DRB Application No.: 07DRB-70164 (P&F)

Project # 1006713

Project Name: LANDS OF HUBERT R TEAGUE

DEVELOPMENT REVIEW BOARD – SPEED MEMO

PLAT OF
 LOT A-1
 LANDS OF HUBERT R. TEAGUE
 PROJECTED SECTION 32, T. 11 N., R. 3 E., N.M.P.M.
 ELENA GALLEGOS GRANT
 CITY OF ALBUQUERQUE
 BERNALILLO COUNTY, NEW MEXICO
 JULY 2007
 SHEET 2 OF 2

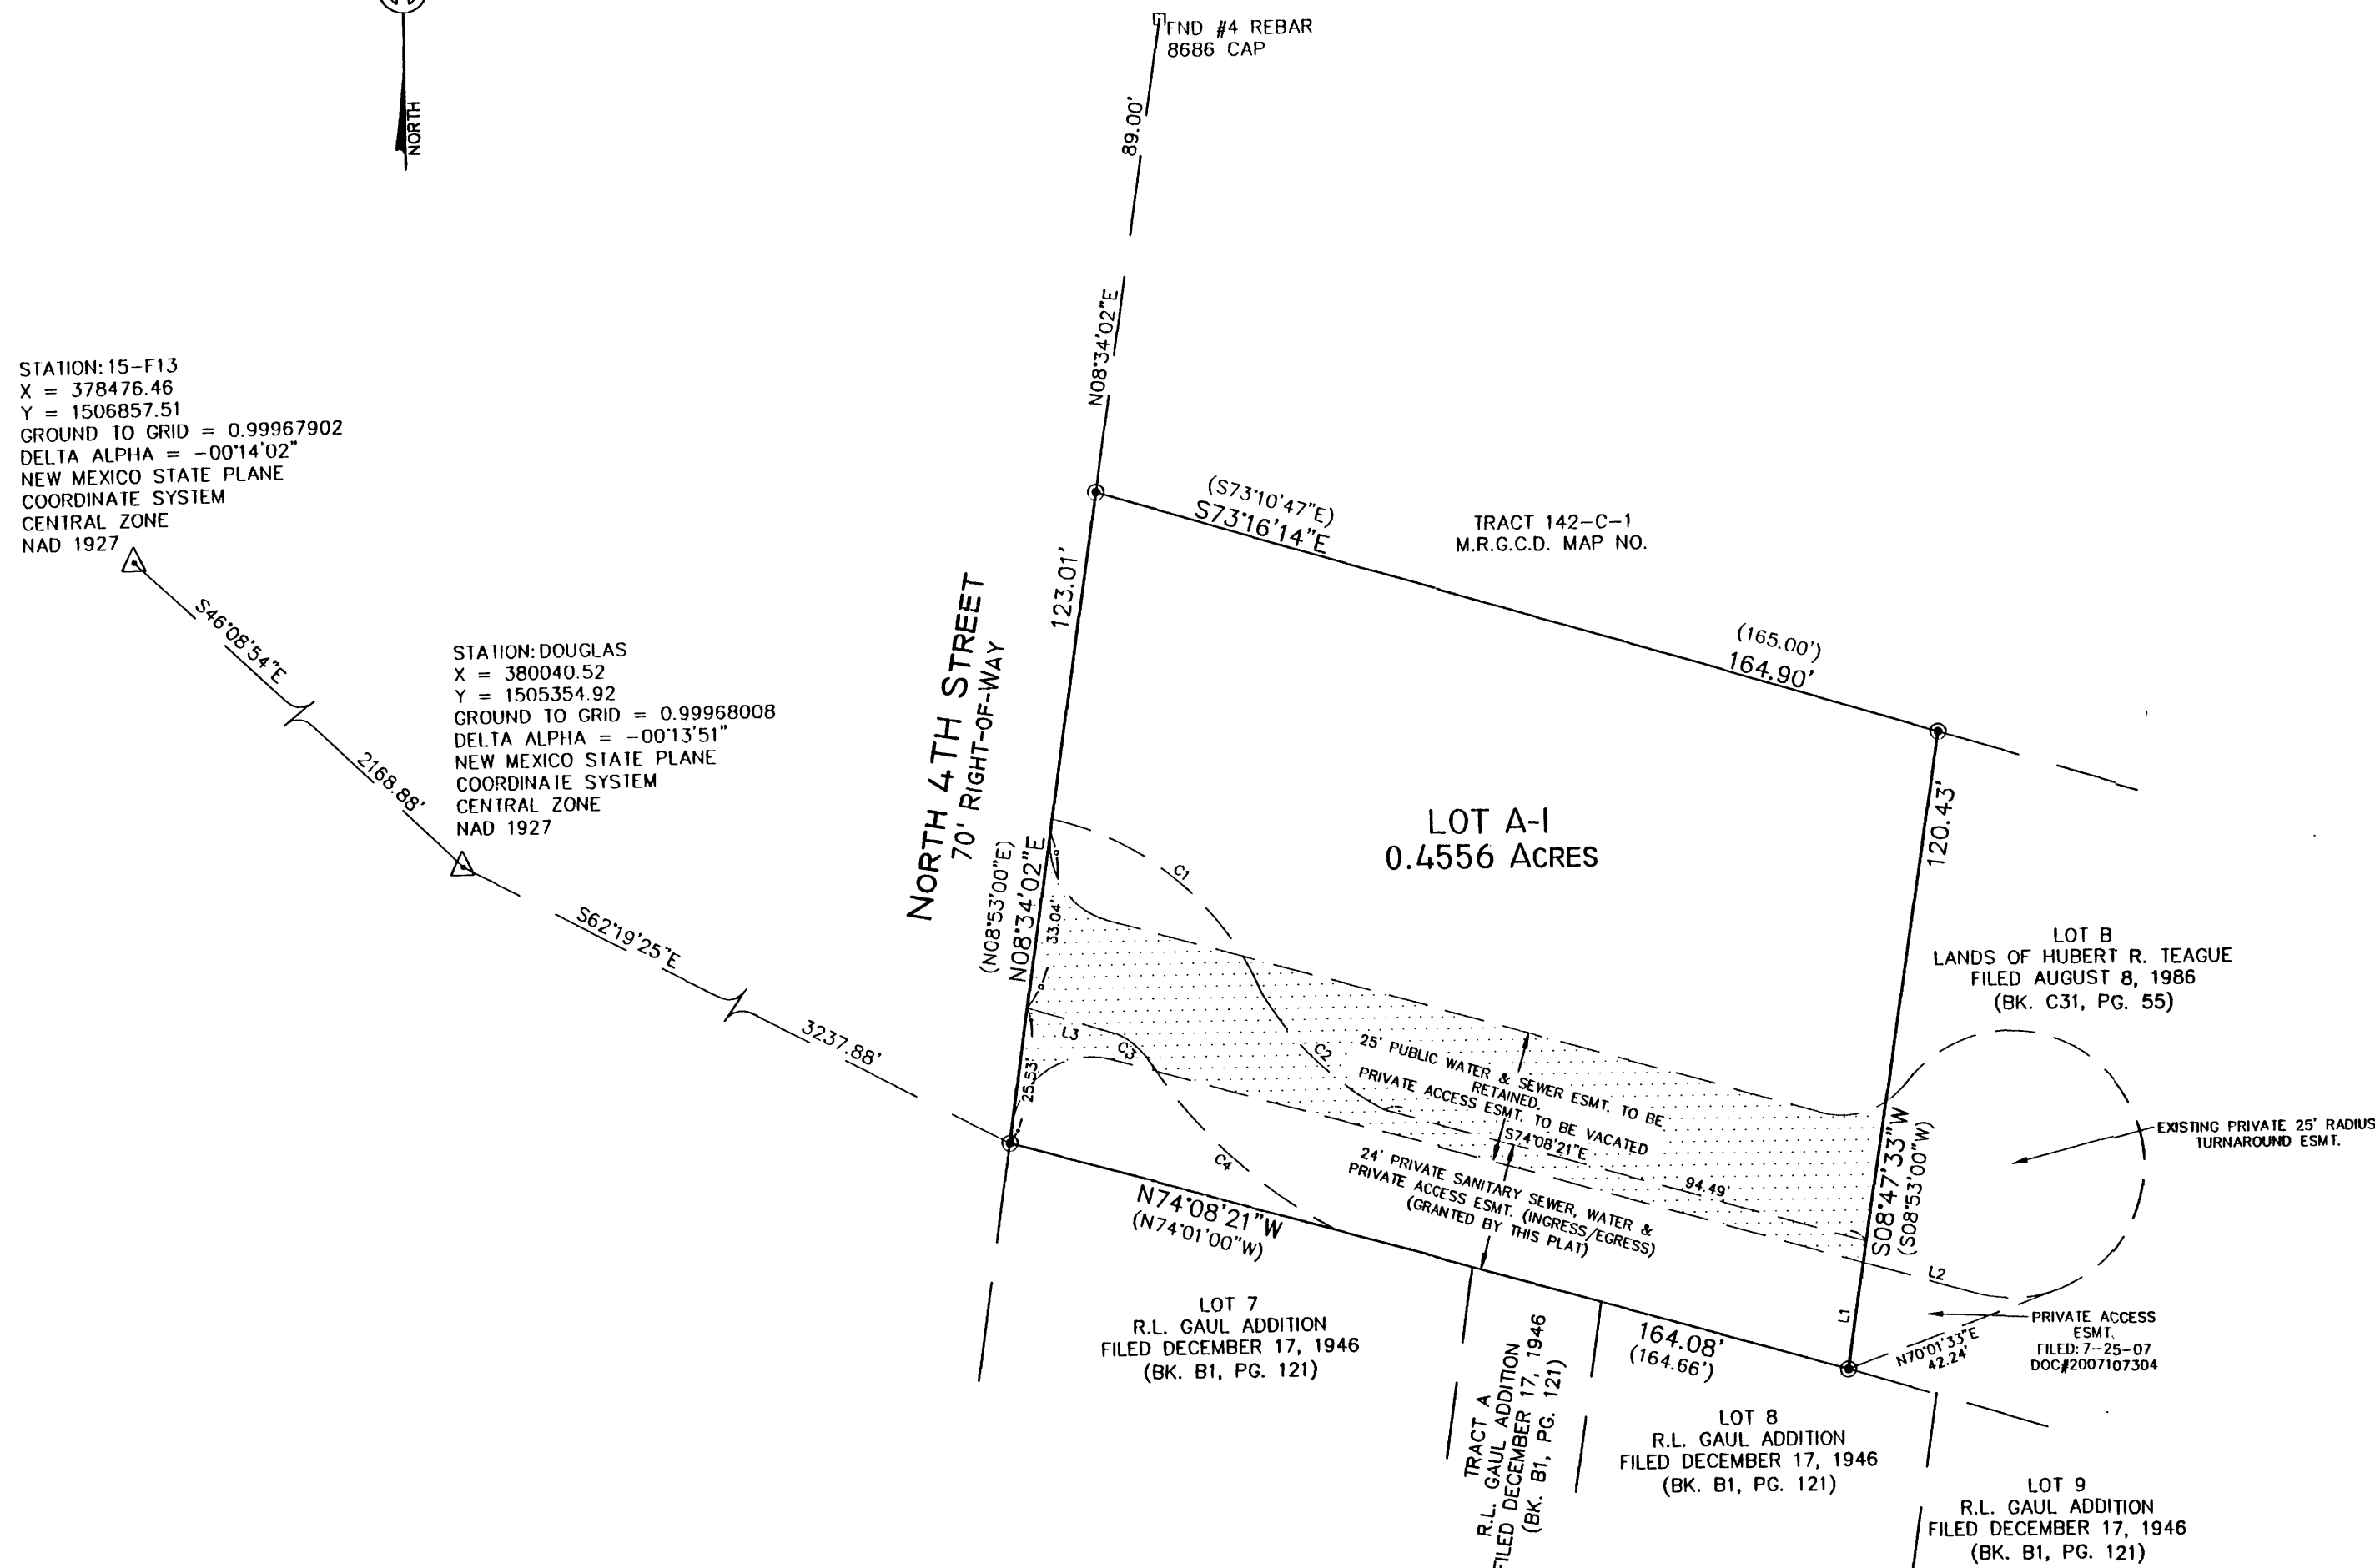
TRANSPORTATION: X RECONFIGURE EASEMENT

ABCWUA: Add private water/sewer easement w/ maintenance & beneficiaries.

The subject application requires that the plat must contain the following language regarding the installation of solar collectors developed within an area for which DRB approval is sought::

Section 14-14-4-7(B) states, "No property within the area of requested final action shall at any time be subject to a deed restriction, covenant, or building agreement prohibiting solar collectors from being installed on buildings or erected on the lots or parcels within the area of proposed plat. The foregoing requirement shall be a condition to approval of this plat or site development plan for Subdivision."
